Our Case Number: ABP-316119-23

Re: DART+ South West Electrified Heavy Railway Order - Hazelhatch & Celbridge Station to Heuston Station,
and Hesuton Station to Glasnevin
County Dublin and County Kildare

DART+ South West submission

Figure 5-102 South Circular Road Junction – Proposed Road Works in Plan

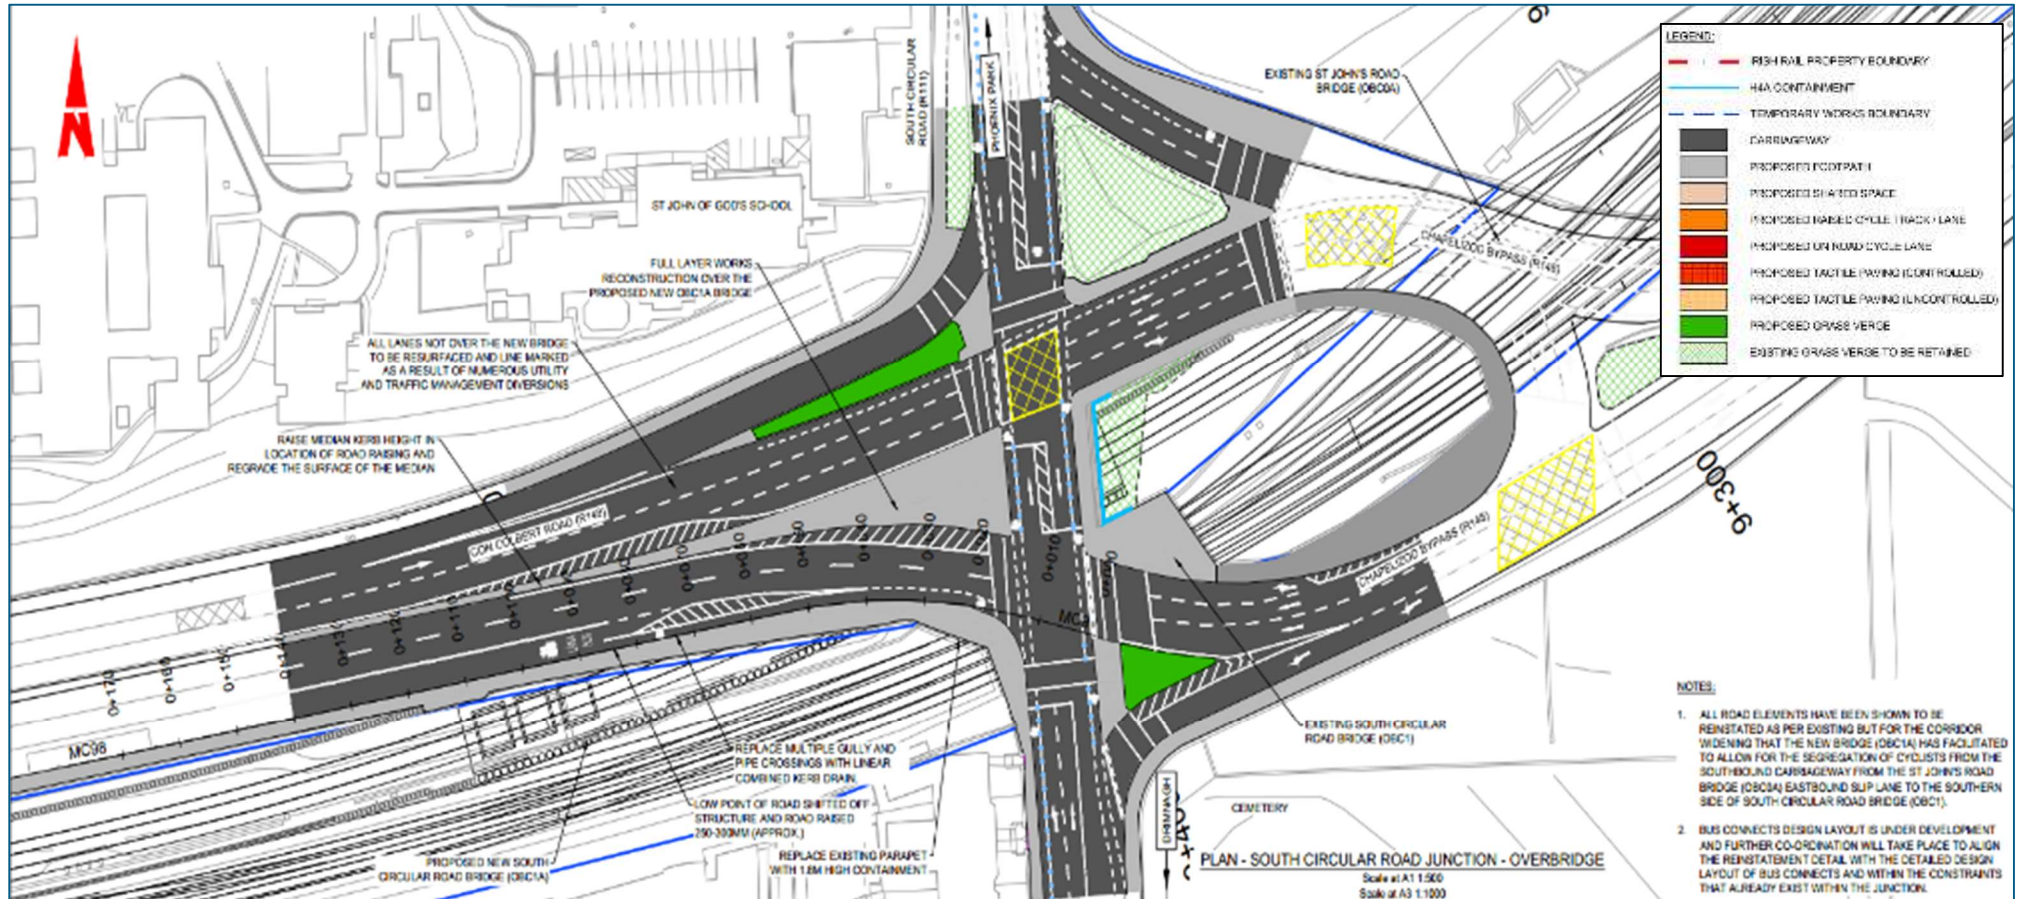
The reinstatement of the Chapelizod and South Circular Road Bypass to the same road design is a missed opportunity to enhance active travel infrastructure linking Kilmainham and Islandbridge and to improve active travel connectivity to Heuston Station. There is currently no cycle provision on the Chapelizod Bypass road heading west through the roundabout or turning right onto the South Circular Road.

We note the lack of consideration given to the redesign of this junction included in the BusConnects application currently before An Bord Pleanála and seek clarification on which plan will be implemented.

Figure 5-117 Proposed Heuston West Station Layout

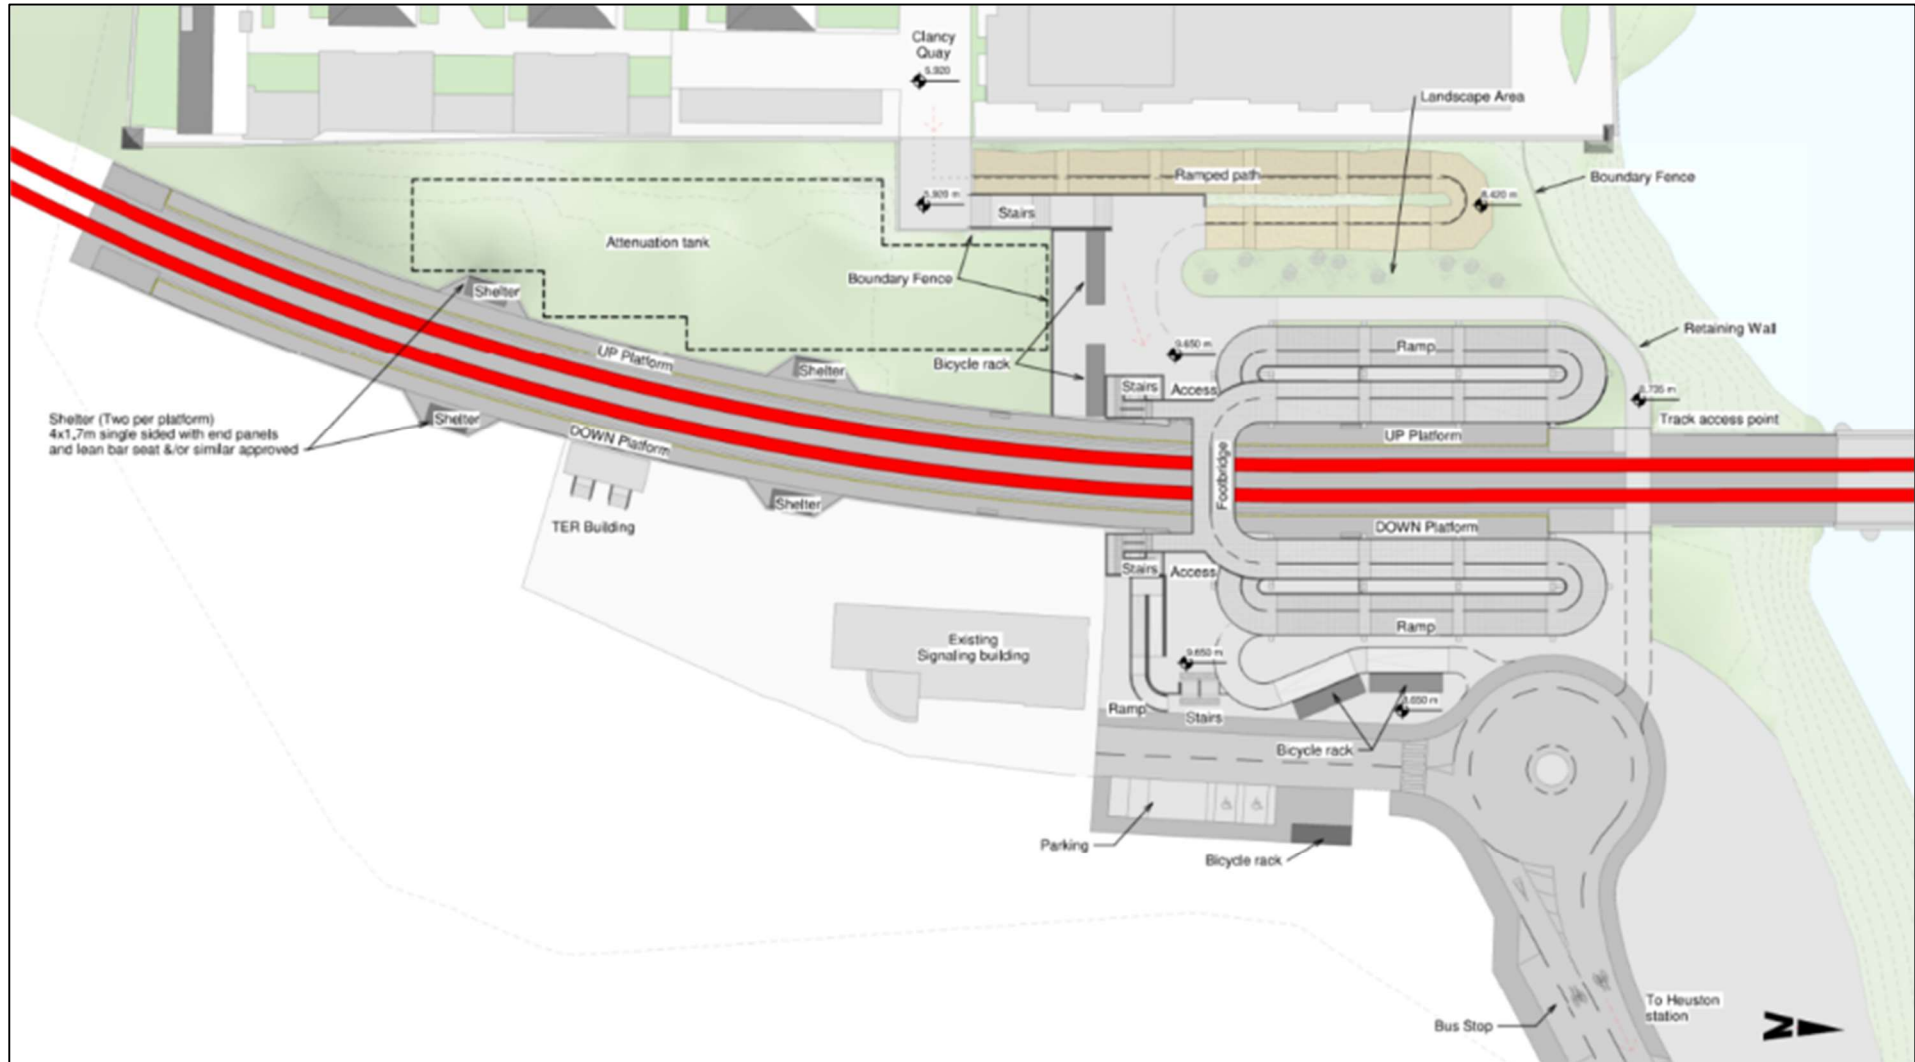
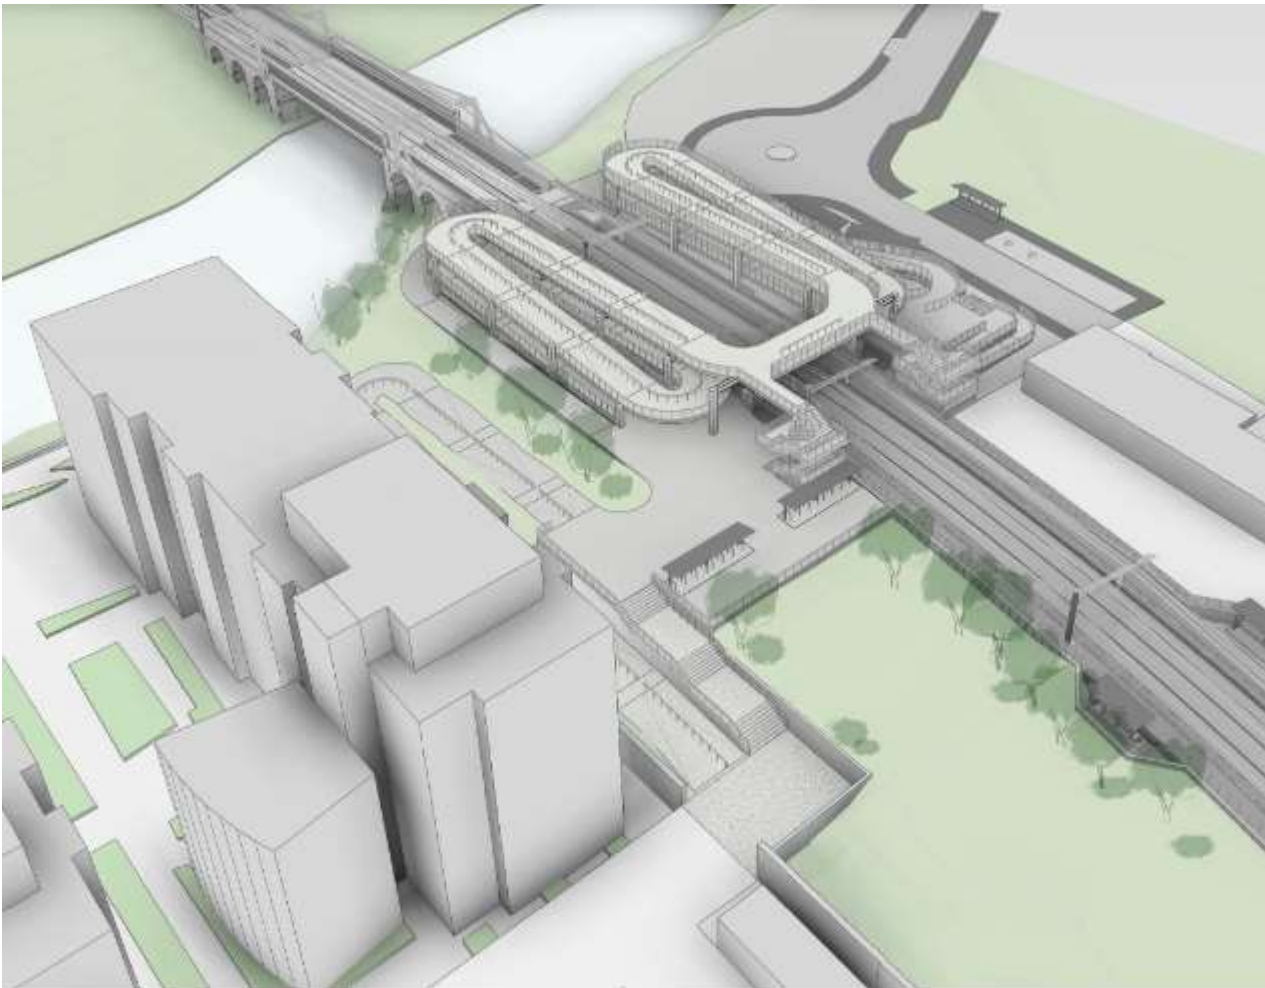
While we welcome the greater accessibility of the new DART fleet, this accessibility won't be of any use if passengers cannot reach the platforms due to the lack of lifts. While ramps may serve a purpose as an alternative to lifts, they cannot be the only accessible provision for platform access as it has been proposed for the Heuston West station.

It is noted that the Heuston Station design includes a ~4m ramped incline from the Clancy Quay side which would be followed by another ~6m ramped incline and decline to access the DOWN Platform. We ask that the project team liaise with accessibility groups on the design of all stations to get a greater understanding of the design impact.

The ramp-only design included in these plans has been most recently shown to be discriminatory and impractical at the new Pelletstown station built in 2021. One wheelchair user told us that it takes her five minutes to move from one side of Pelletstown station to the other when pushed. It's completely unacceptable that Irish Rail would propose to continue discriminating against people with reduced mobility in a brand new station. It is vital that lifts are included in the designs for Heuston West, Cabra, and Kylesmore stations, and in any other future stations.

The current provision of Bike shelters at the Heuston West Station is welcomed but as a new station which should cater for more active travel there should be a provision for Bike lockers included in the plan. It is noted that Heuston has 69 bike lockers in place but Heuston West needs its own provision given the distance from the main Heuston station. The provision of bike lockers should be included in the station design. It is noted that the CIE Heuston Masterplan includes provision for extensive bike parking with 5,000 bike parking spaces but the current station design for Heuston west only offers standard bike shelters. We think that the Heuston West station design should be built with a provision for secure bicycle parking as has recently been completed at the Amsterdam Central station. This offers a secure bike parking location for those taking longer trips and includes double racks to enhance bike parking capacity and a variety of racks/spaces to facilitate mobility options including cargo bikes.

The proposed access to Heuston West station through to Heuston Station Road features unsafe roundabouts, cyclists mixing with bus parking bays and an unnecessarily wide road. This design simply does not comply with the Design Manual for Urban Roads and Streets or the National Cycle Manual. Irish Rail must be made to redesign it.

This project has provided for an abundance of car parking at Heuston West. This is a crucial public transport link in the city centre and the number of car parking spaces should be limited to service vehicles and blue badge holders. This will free up space to construct appropriate sheltered and secure cycle parking with the necessary bike maintenance and charging facilities. Encouraging people to drive to this location is antithetical to the project's stated goals of reducing transport emissions as part of the State's Climate Action Plan 2023.

Figure 5-118 Pedestrian Transfer Route Upgrades

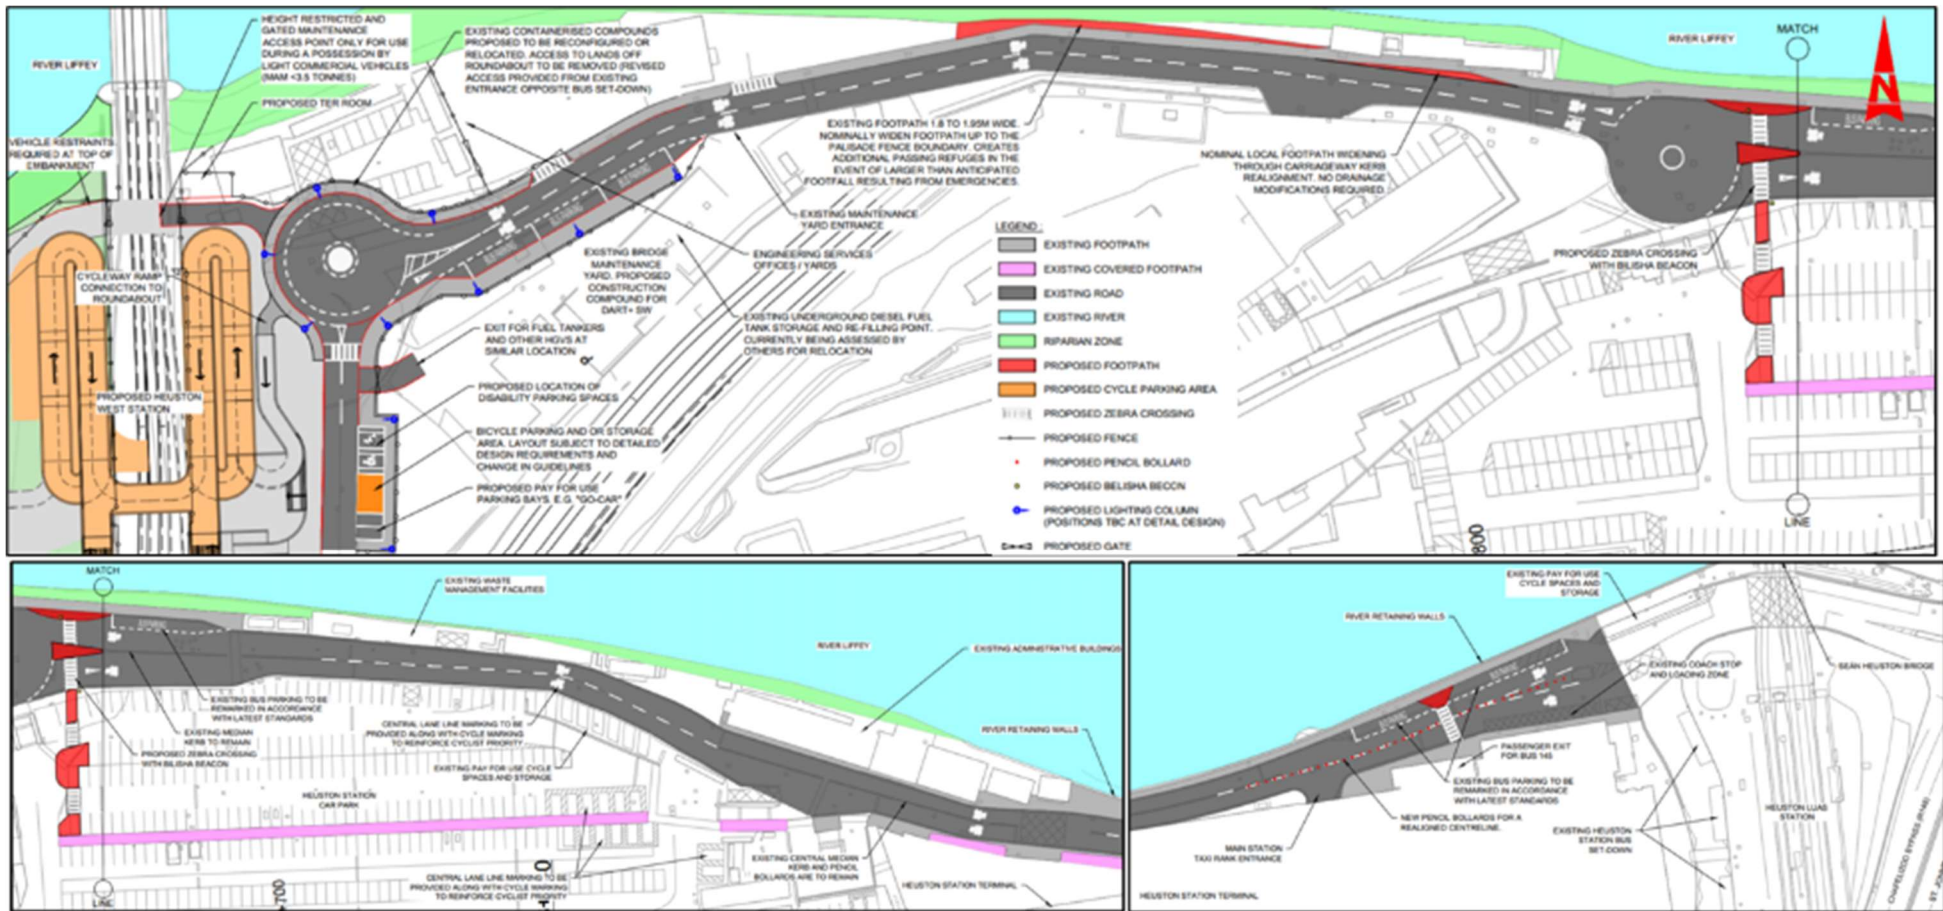
The Heuston West station is a considerable distance from Heuston Station, the Heuston Luas stop, and surrounding areas. A convenient and safe walking and cycling route needs to be built to ensure ease of access to the new Heuston West station. From the plans, it is not clear if access to Heuston West station from Clancy Quay is open to the public or just to residents of Clancy Quay. Public access through Clancy Quay is crucial for increasing access to the station from both sides of the river.
